Subject: RE: Few other points RE: FW: Taco Bell at 1363 Washington Avenue, Portland, ME

Based on an email I received yesterday from Angel please note the below responses pertaining to your previous comments.

Not Approved for Construction
Drawing Title
Layout & Materials

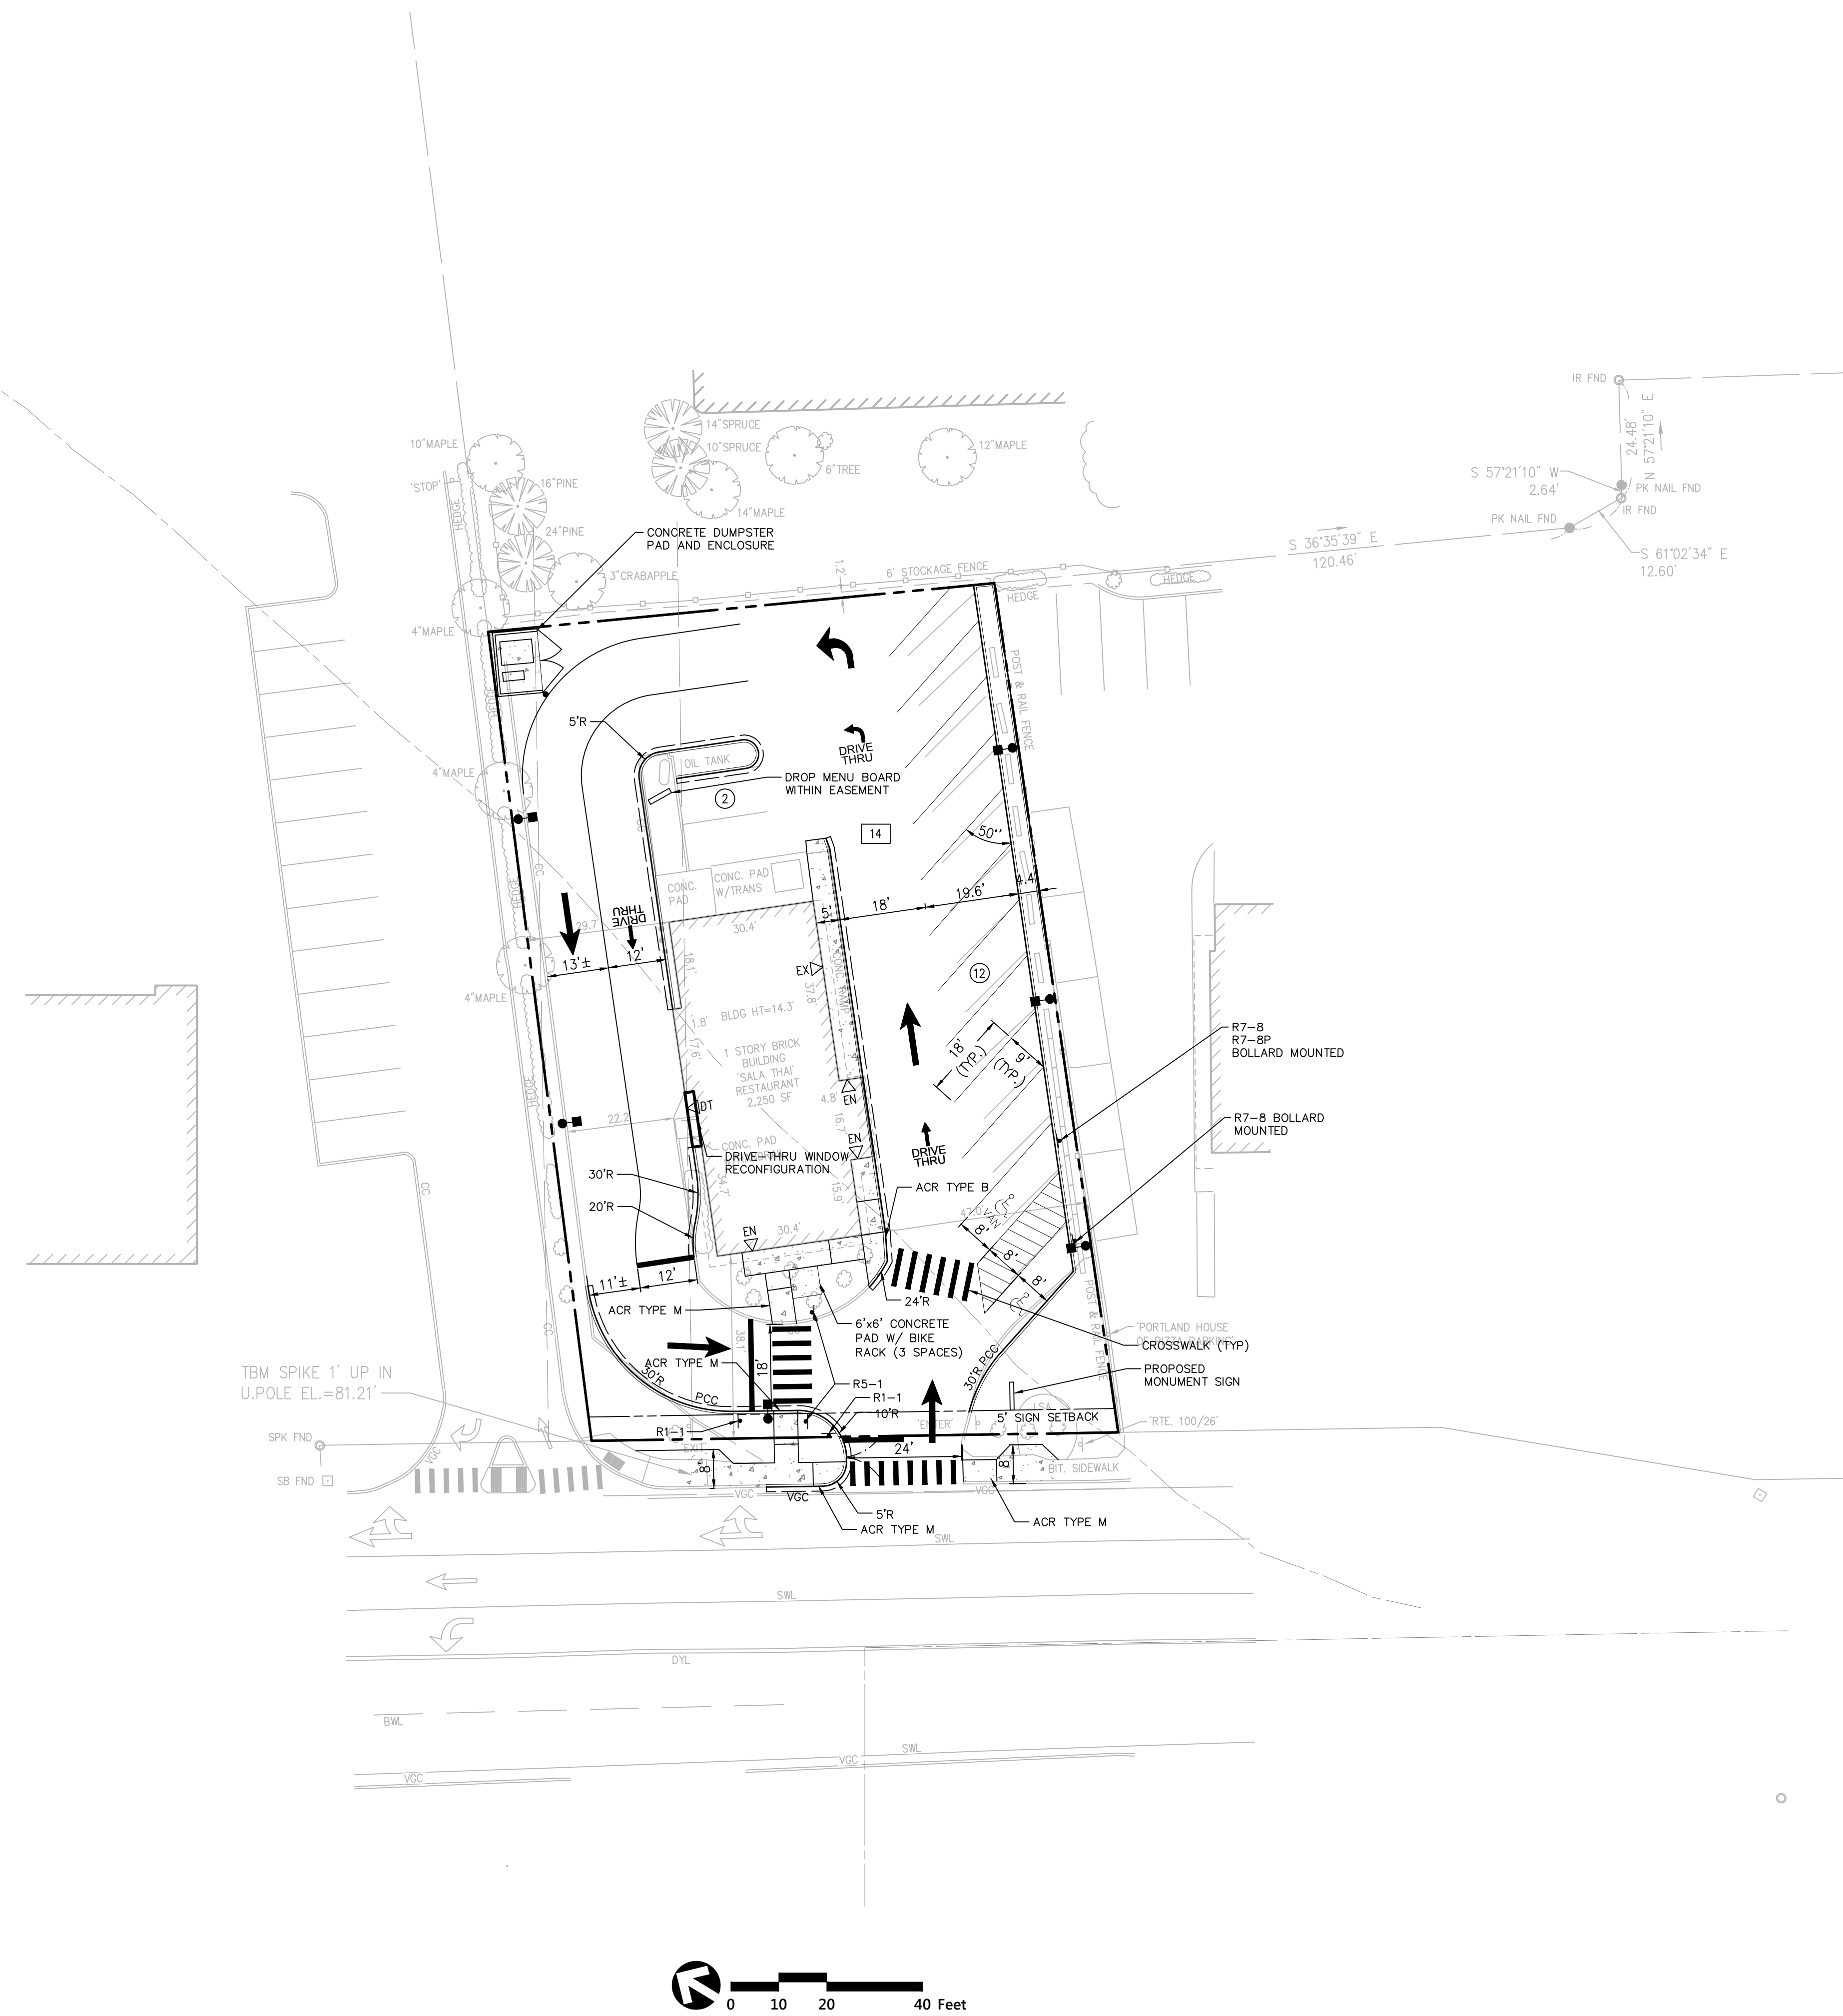
2. The material of the slat wall is aluminum per the attached detail and we have updated the rendering to state the material accordingly.
3. See attached updated site lighting plan/photometric which includes building light sconces noted (fixture TB on the attached photometric plan). Pertaining to the parking lot lights (fixture A on the attached photometric plan), the site lighting vendor has changed the fixtures from 396W fixtures to 52W fixtures and reduced the pole height from 25' to 17'-6" along with changing the location of some poles. This brings the light levels below the 5 fc maximum allowed. Average noted on the photometric plan is 1.25 (1.25 average intended per code). The max illumination at a property line per code is stated at 0.1 FC except where abutting industrial or other non-sensitive area. As the adjacent sites are similar in nature (no parks, residents, etc) the photometric plan should meet the intent of the code.
